SCOPING OPINION:

Proposed Lostrigg Solar

Case Reference: EN0110004

30 July 2024

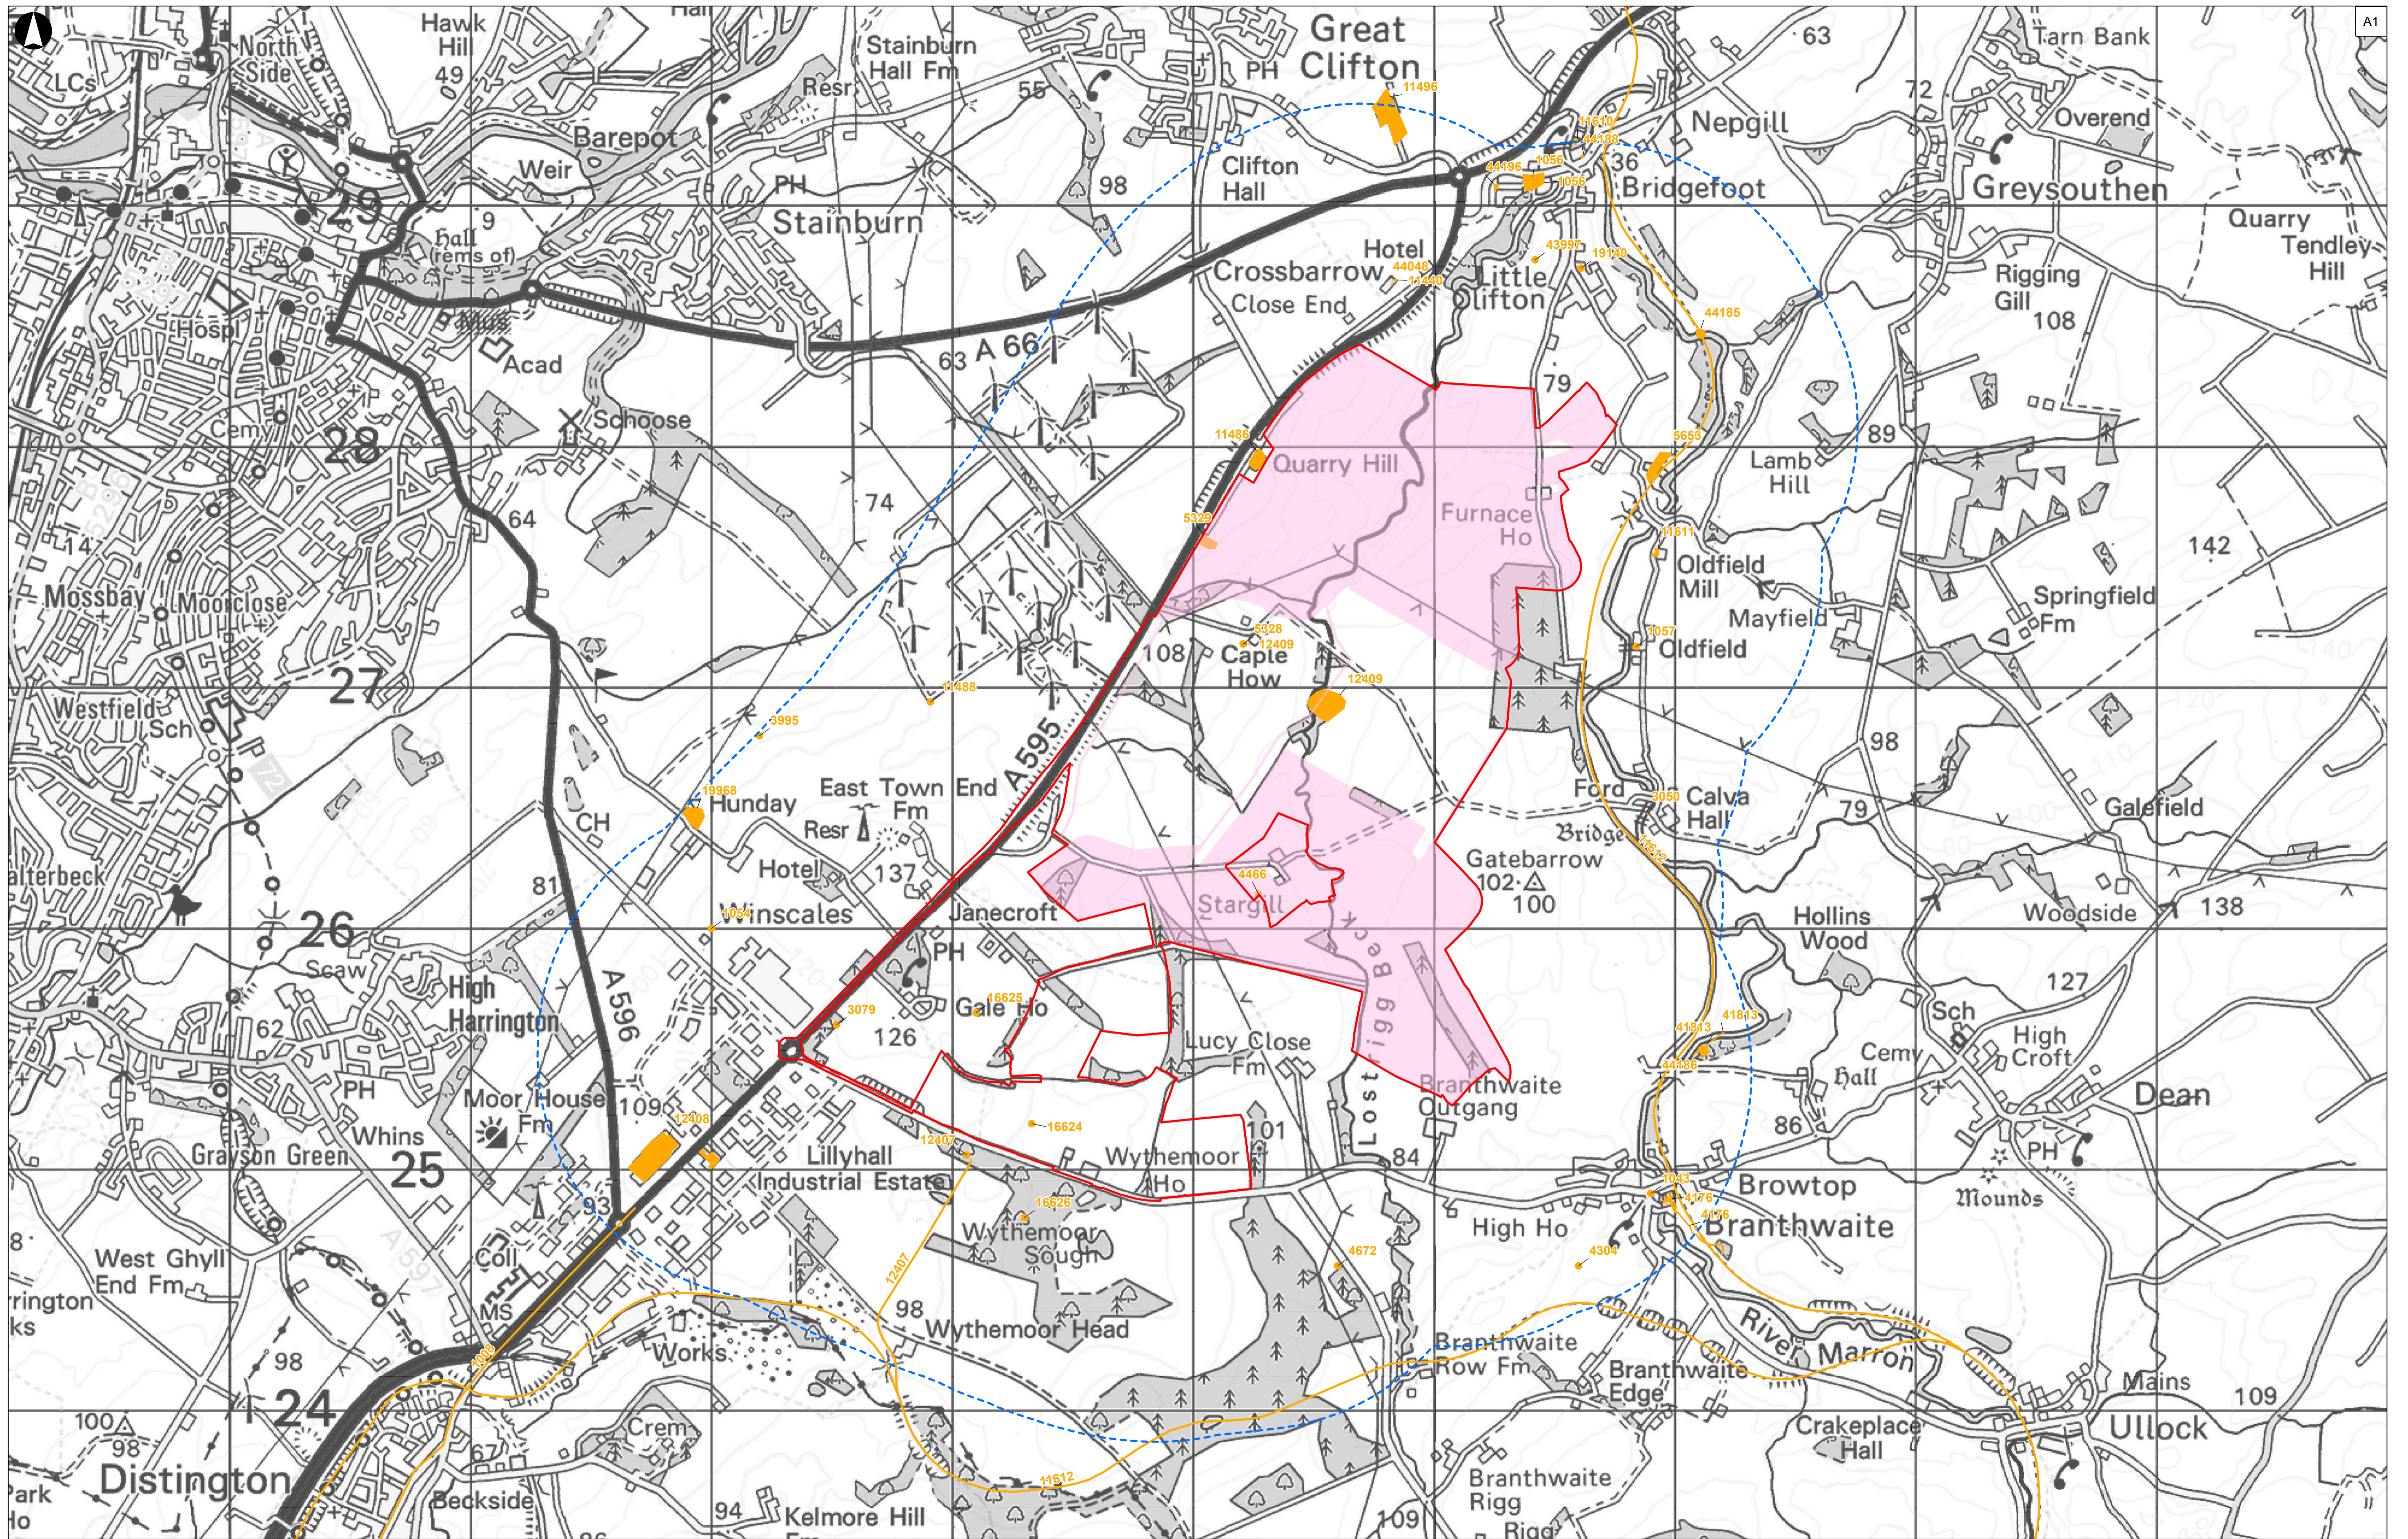
ID	Ref	Description	Inspectorate's comments
355	Figure 9.1	Map legend	Figure 9.1 of the Scoping Report depicts designated heritage assets within a 3km study area of the Proposed Development. Grade I Listed Building are represented by a red dot and Grade II Listed Buildings are represented by an orange dot. It is not possible to differentiate between these colours which makes the figure difficult to understand. The Inspectorate considers that the ES should include a plan which clearly shows the different grading of Listed Buildings in the study area.
356	Paragraph 9.4.1.1	Study Area	The Scoping Report states that the study area is 3km and 1km for designated and non-designated assets respectively. It is explained that this distance is considered appropriate and is informed by professional judgement. It should be clear how the approach taken ensures that any heritage assets or conservation areas with long views towards or out from the Proposed Development have been identified and considered.

Legend
 draft Order Limits
 1km Study Area

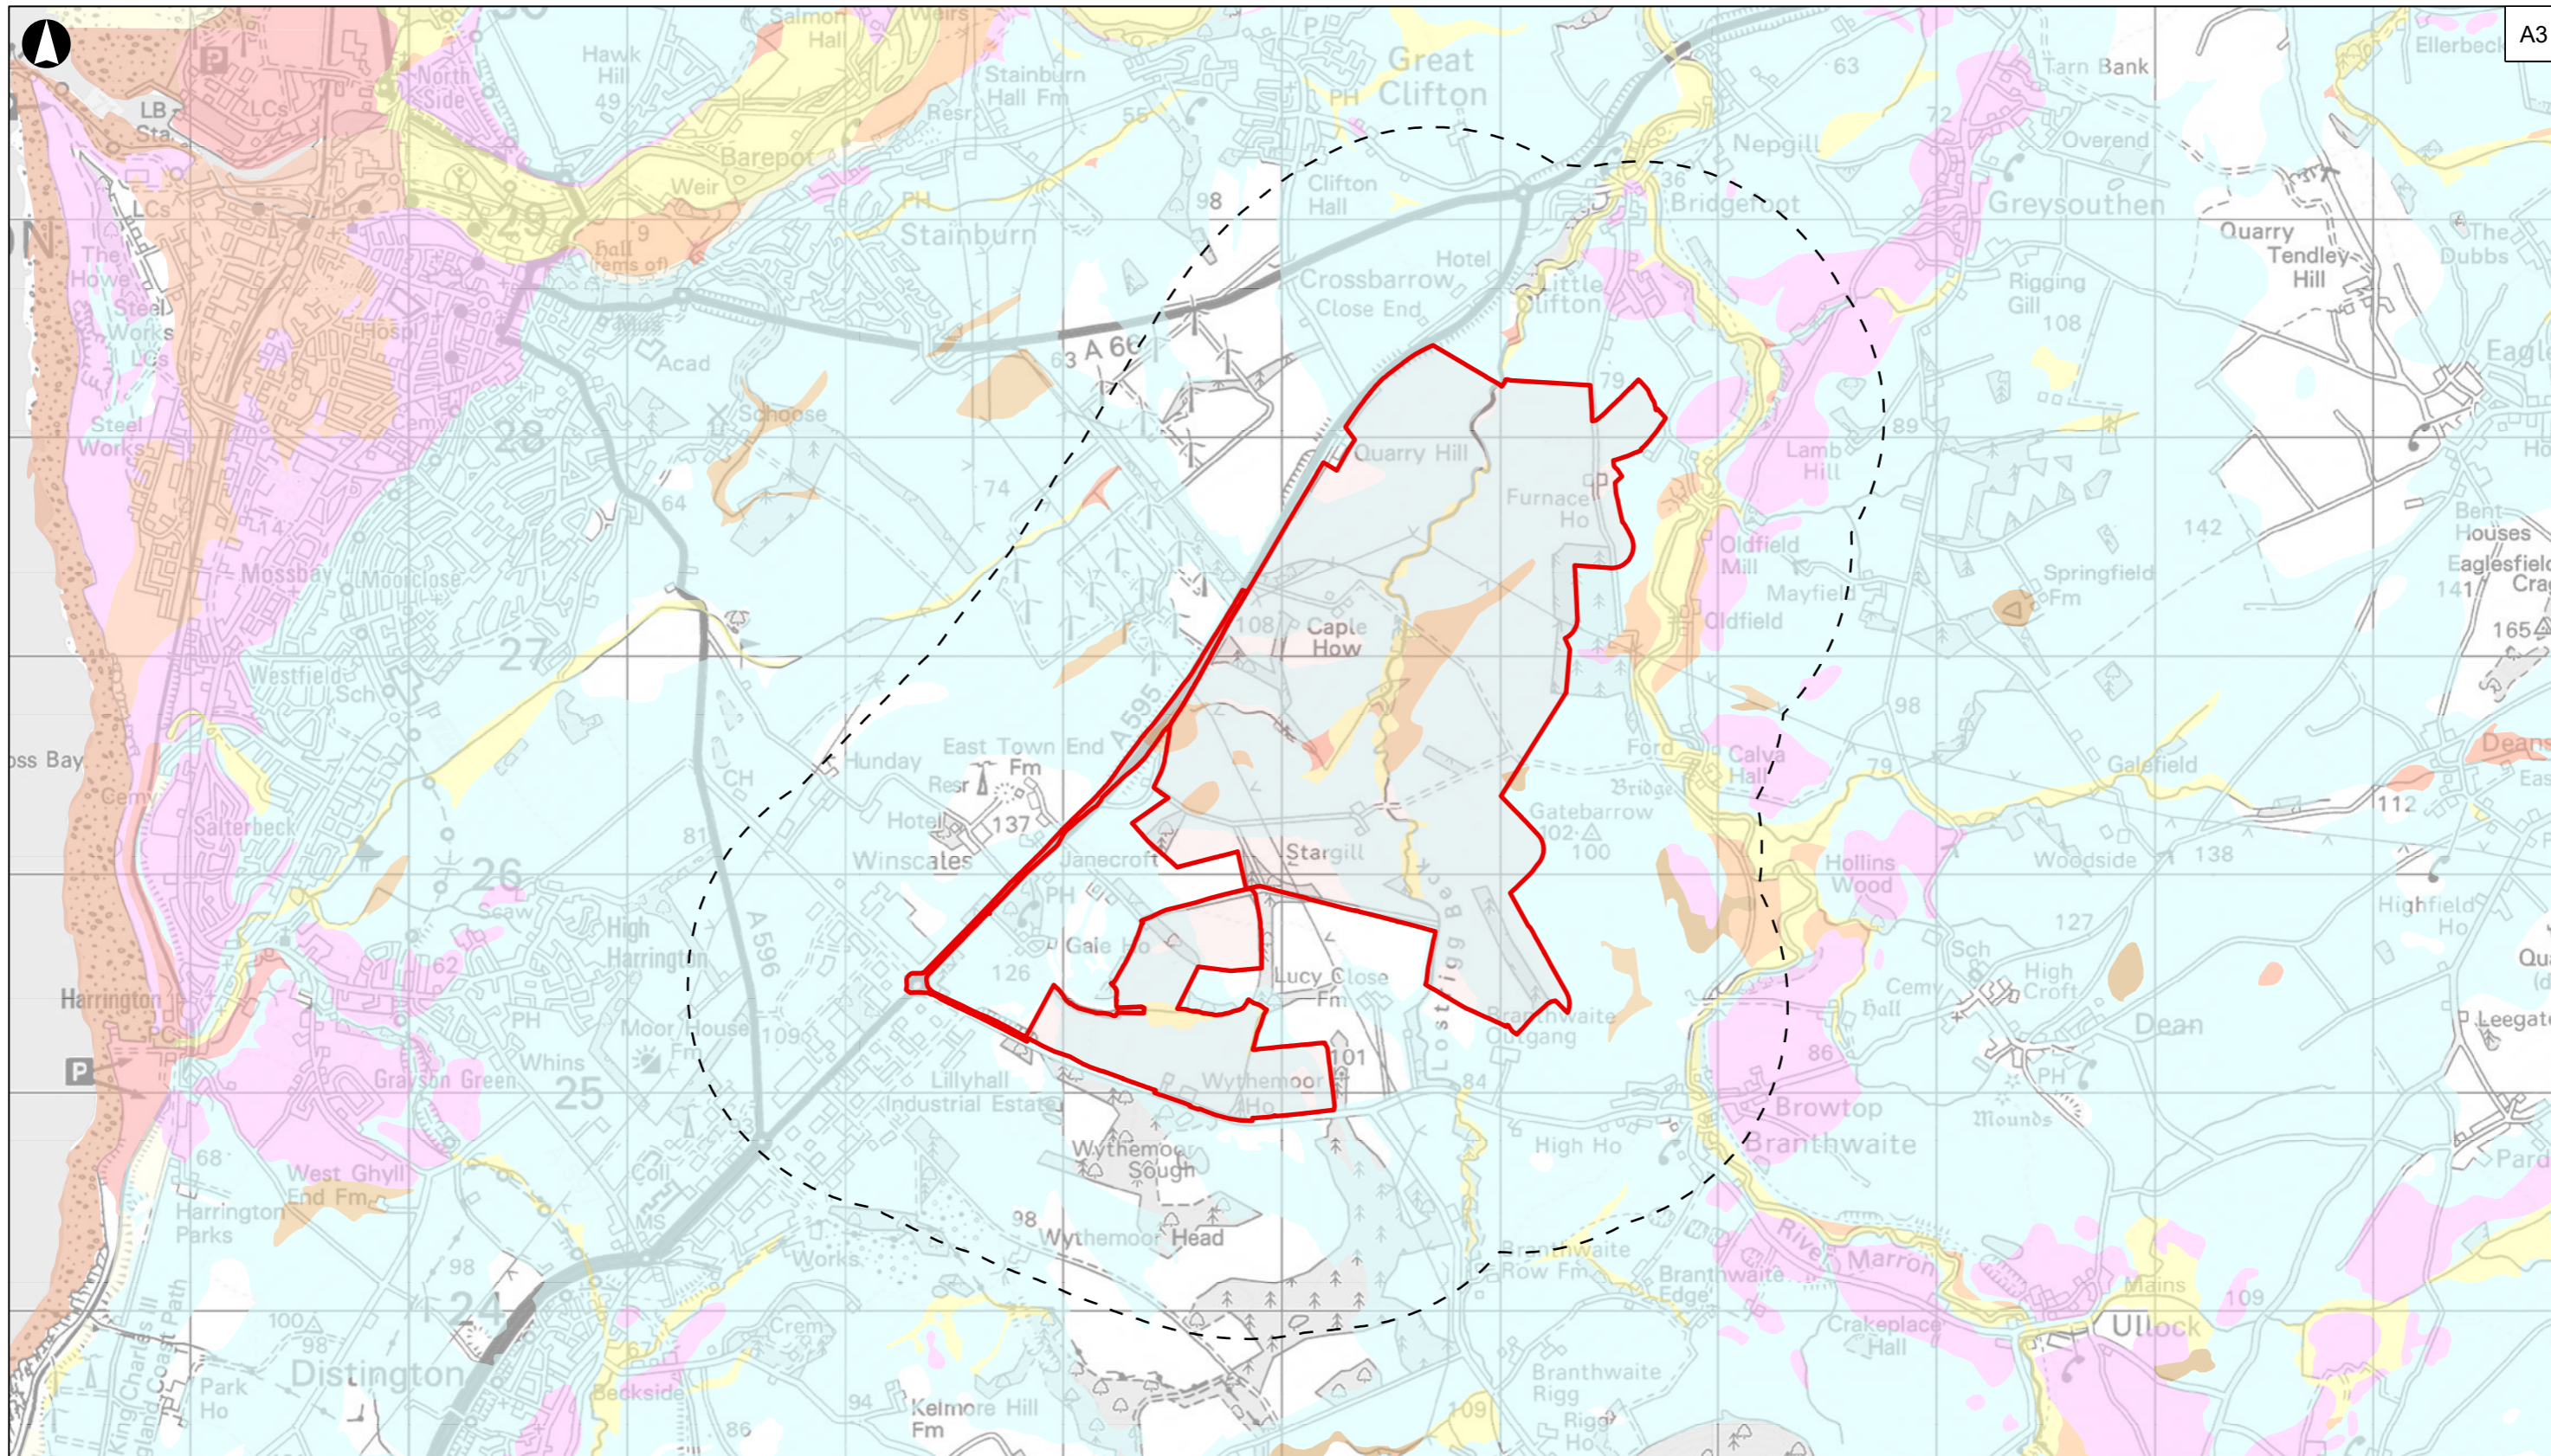
ID	Ref	Description	Inspectorate's comments
3.14.2	Section 18.4 and Figure 18.1	Study area	The study area is shown on Scoping Report Figure 18.1 however the Scoping Report does not provide any explanation or justification for the use of 1km buffer around the order limits for the study area. This should be clearly explained in the ES.

3.14.3	Figure 18.1	Ordinary watercourse	In their response, the Environment Agency have noted that Figure 18.1 does not show an ordinary watercourse located in the north of the DCO area near to Caple How. The ES should ensure that all water features are depicted on relevant figures and likely significant effects resulting from the Proposed Development on the watercourses should be reported.
